Office of
Environment
& Heritage

DOC19/172842
SSD-8699

**Redevelopment of Greenwich Hospital (SSD-8699) – 97-115 River Road Greenwich -
Environmental Impact Statement**

Redevelopment of Greenwich Hospital (SSD-8699) – 97-115 River Road Greenwich - Environmental Impact Statement

HammondCare  
Greenwich Hospital Concept Plan  
**Landscape Zones**  
Sheet 1 of 4

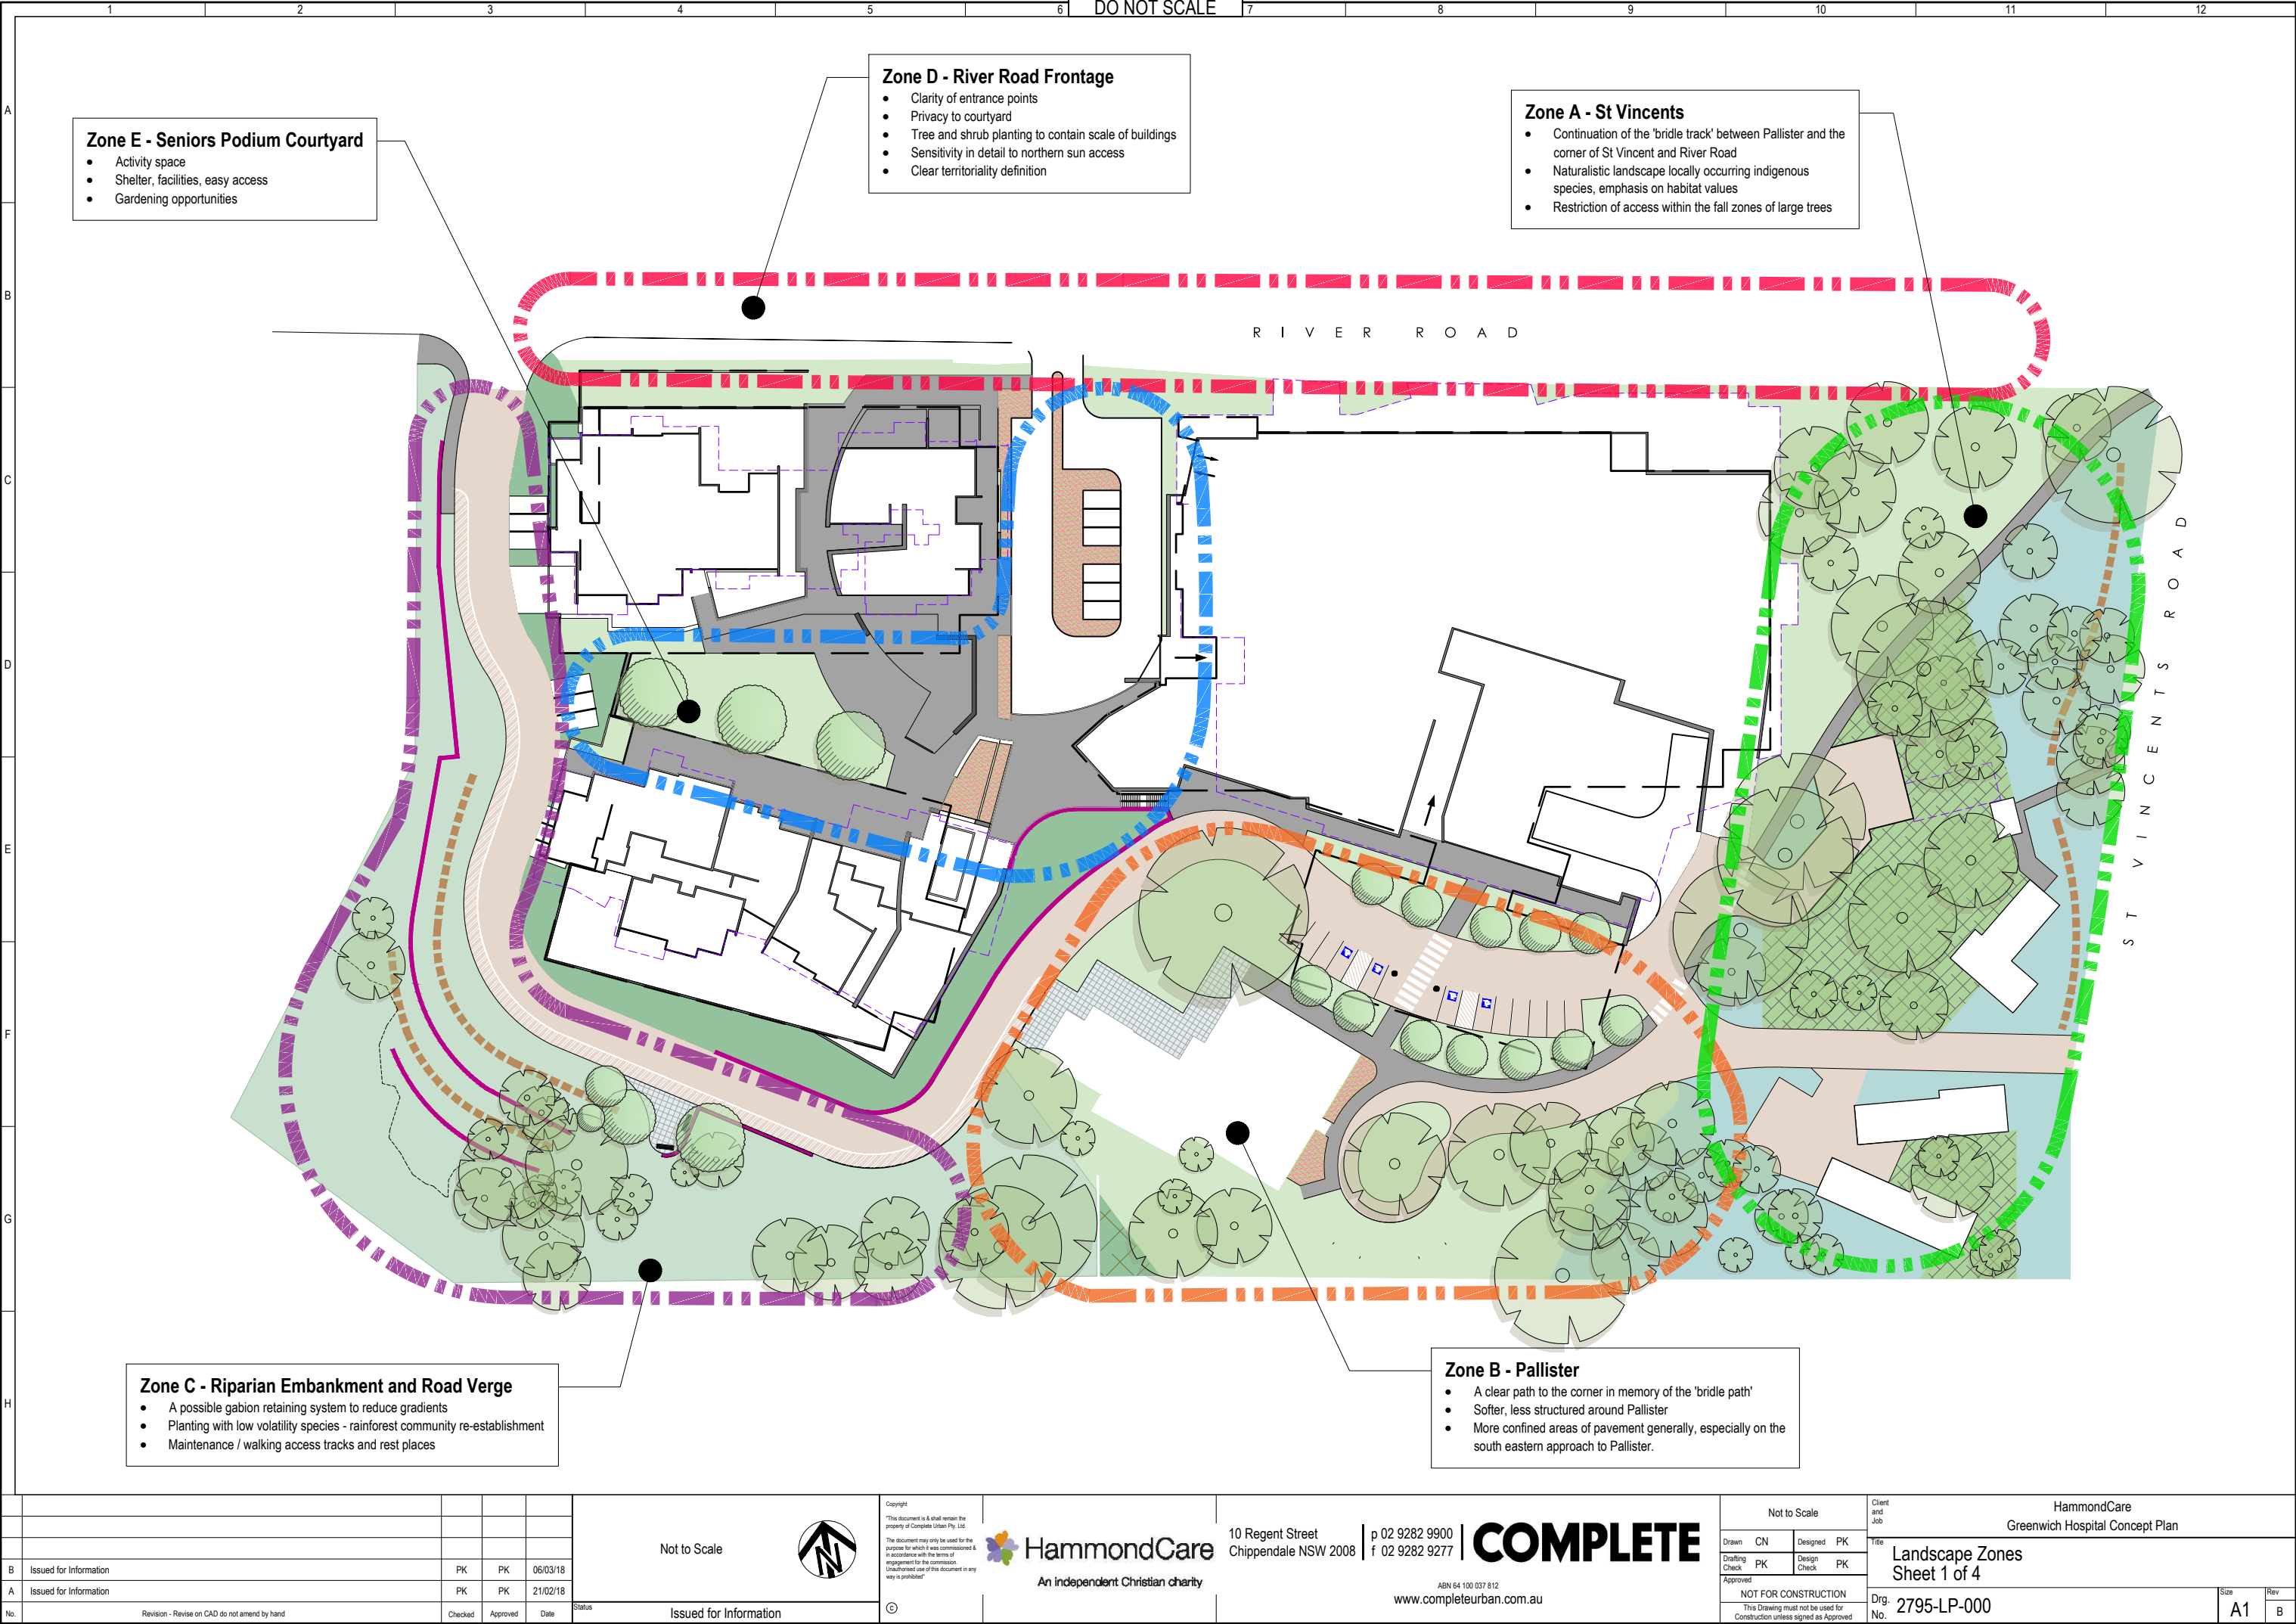
The EIS notes 5 key landscaping zones are proposed for the development (Zones A, B, C, D and E). It notes it is proposed to plant locally occurring indigenous species in Zone A on the eastern side of the site with species from the Coastal Enriched Sandstone Dry Forest (pages 23, 24 and 69). Within Zone C, the EIS indicates it is proposed to establish a plant community generally consistent with the Coastal Sandstone Gallery Rainforest and with the Coastal Sandstone Foreshores Forest (pages 23, 24 and 69). For Zone B, the EIS notes 'new plantings will use species sympathetic to the era of the building' (ie Pallister House) and for Zone E it proposes to use plants which 'emphasise seasonal change and colour' (page 69). Section 10.7 of the EIS however notes it has been recommended that the species included in any landscape plans be informed by locally native species (page 86) and Section 8 of the BDAR indicates the Landscape Plan will aim to reinstate native vegetation associated with PCT 1776 across the site (page 39).

OEH recommends the landscaping for all five landscaping zones at the site uses a diversity of native trees, shrubs and groundcover species from the relevant local native vegetation communities (local provenance material) that occur or once occurred in this location to improve biodiversity rather than use exotic species and non-local native species.

| B Issued for Information                      |  |  |  | PK PK 06/03/18  |  |  |  | Title<br>Site Level<br>Sheet 2 of 4  |  |  |  |

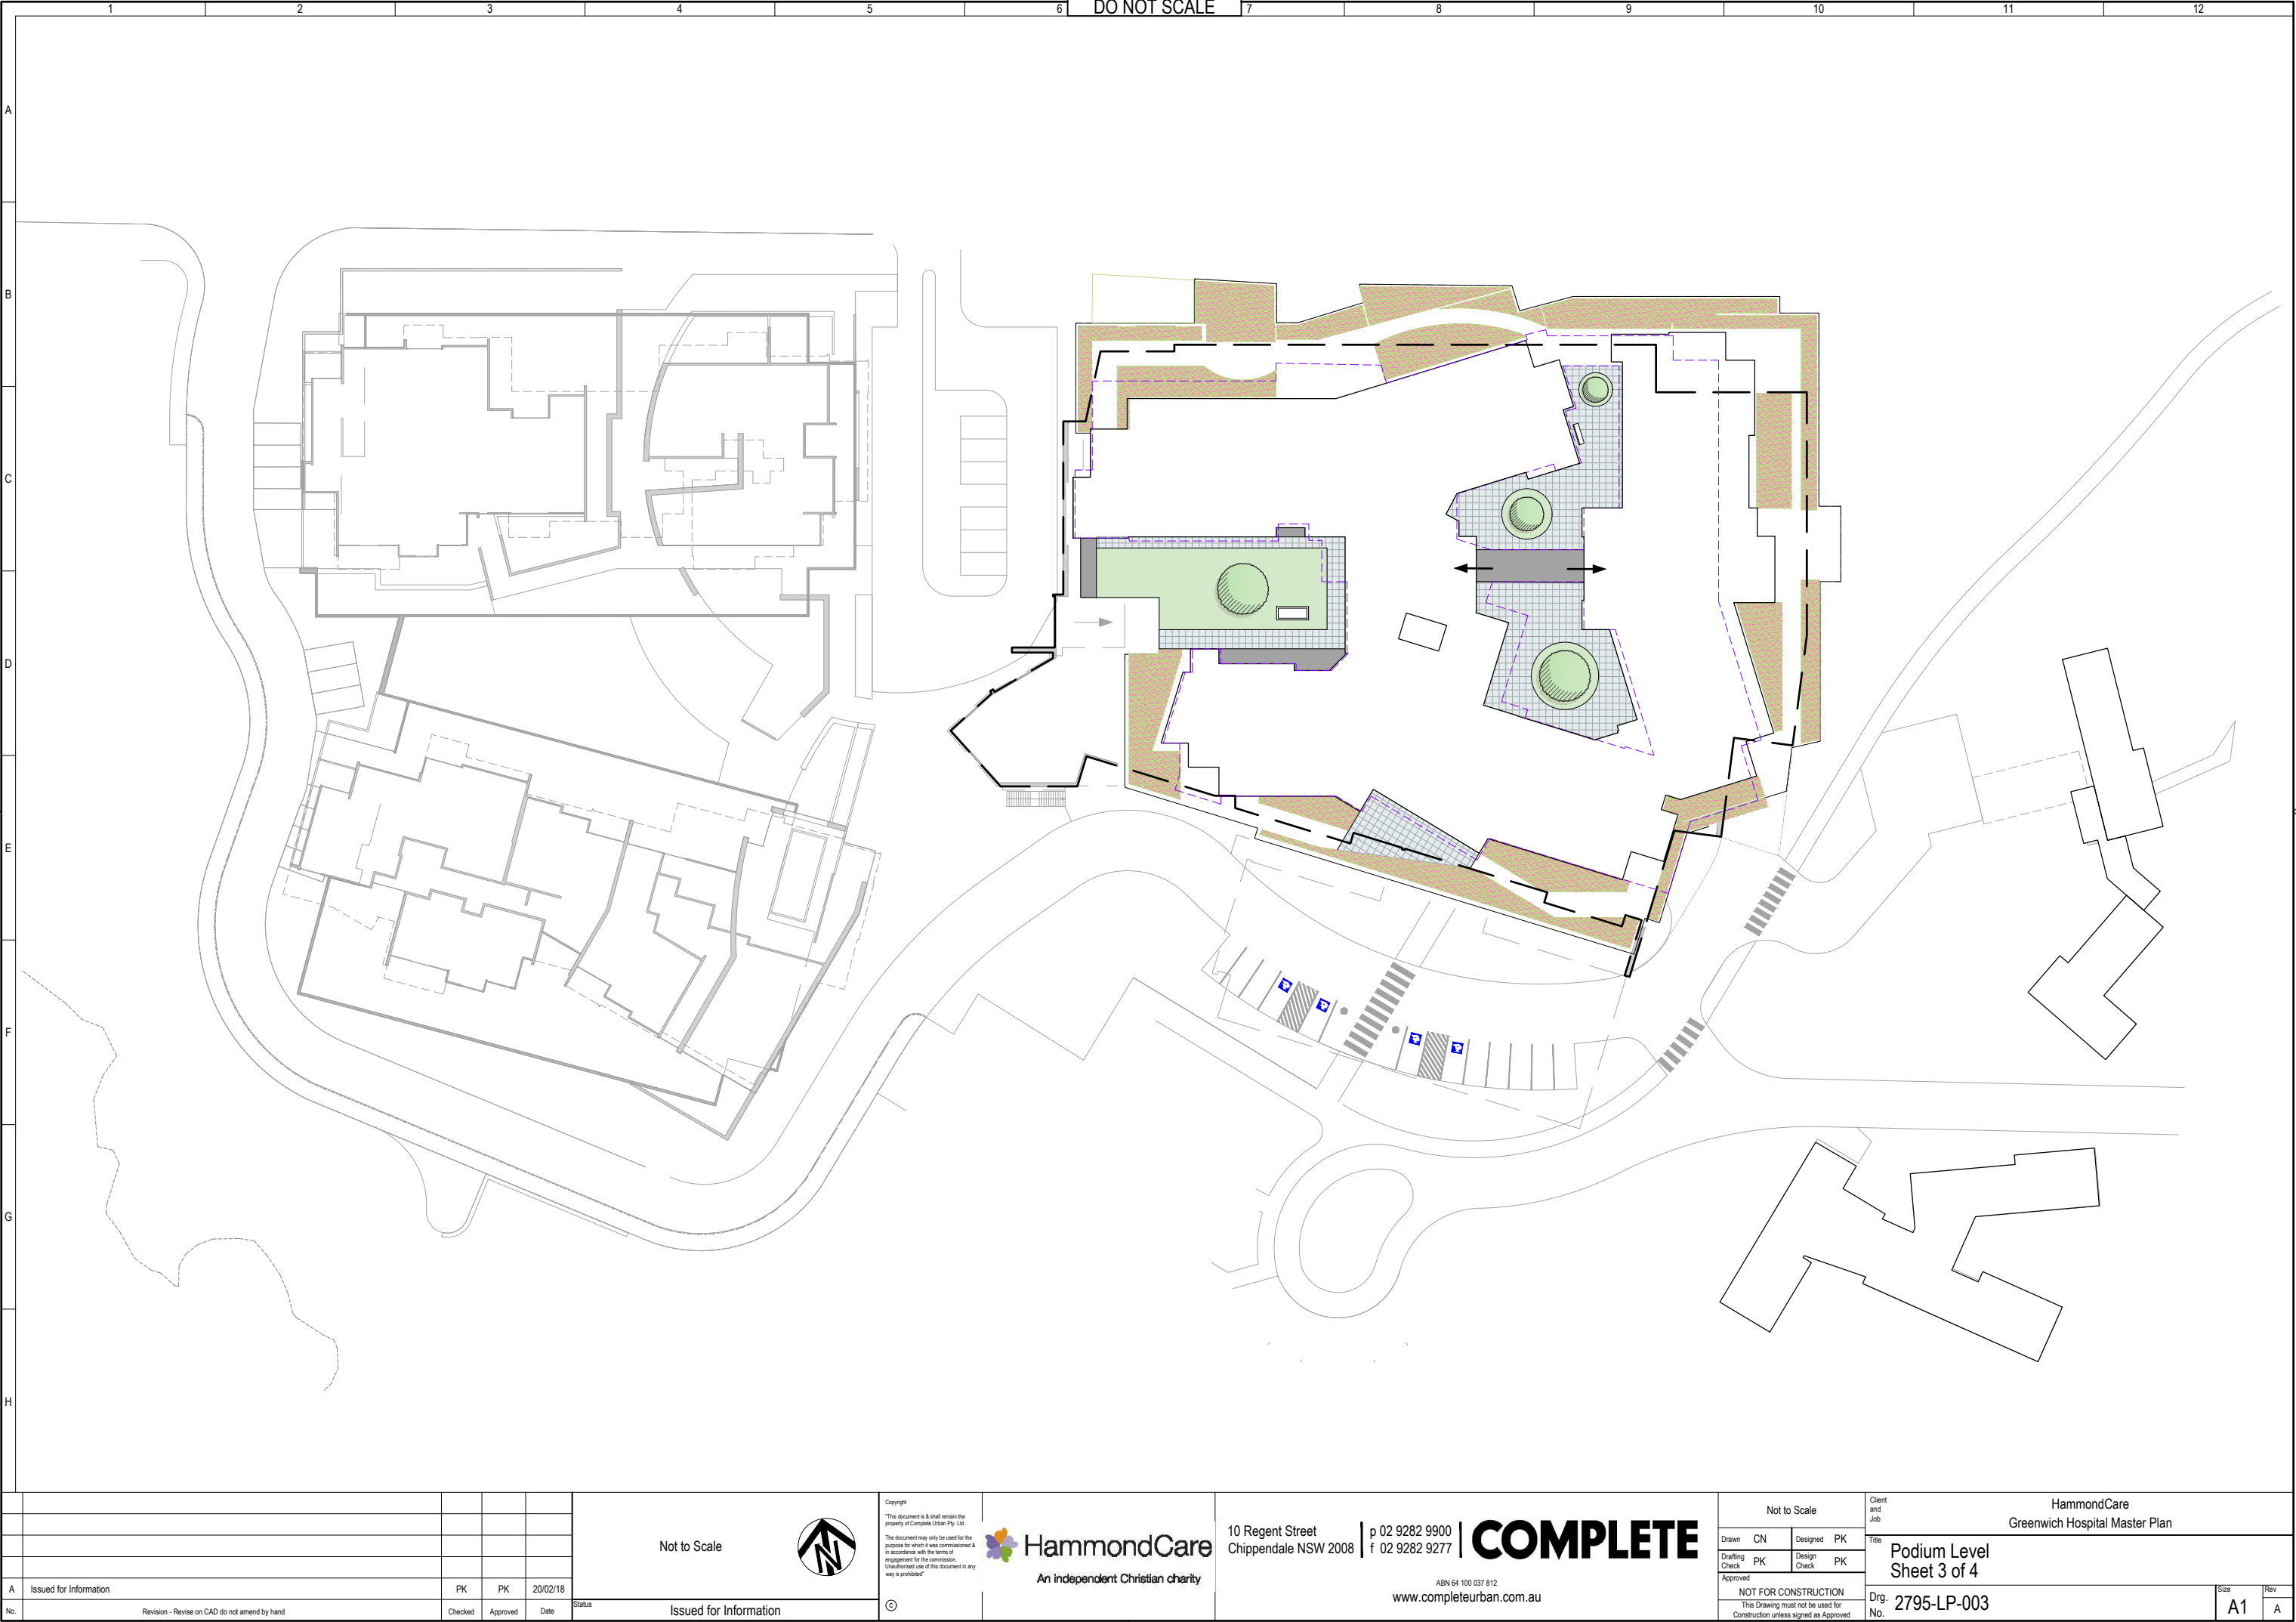
The AIA indicates tree cover will be enhanced by planting advanced specimens and it notes the 131 trees which are nominated for removal will be replaced in greater numbers than the trees removed (page 46). It is unclear how many replacement trees are proposed to be planted and the RTS should address this. In terms of mitigating the urban heat island effect, improving biodiversity, habitat etc at the site OEH recommends:

- advanced size local native trees are planted to replace the existing trees to be removed, as the benefits that the existing trees provide can take decades for a juvenile tree to replace
- the trees that have been approved for removal are replaced at a ratio greater than 1:1
- the RTS provides details on the pot container size of the replacement trees, the number of trees to be planted and the plant species.

Enough area needs to be provided for on the site to allow the planted trees to grow to full maturity.
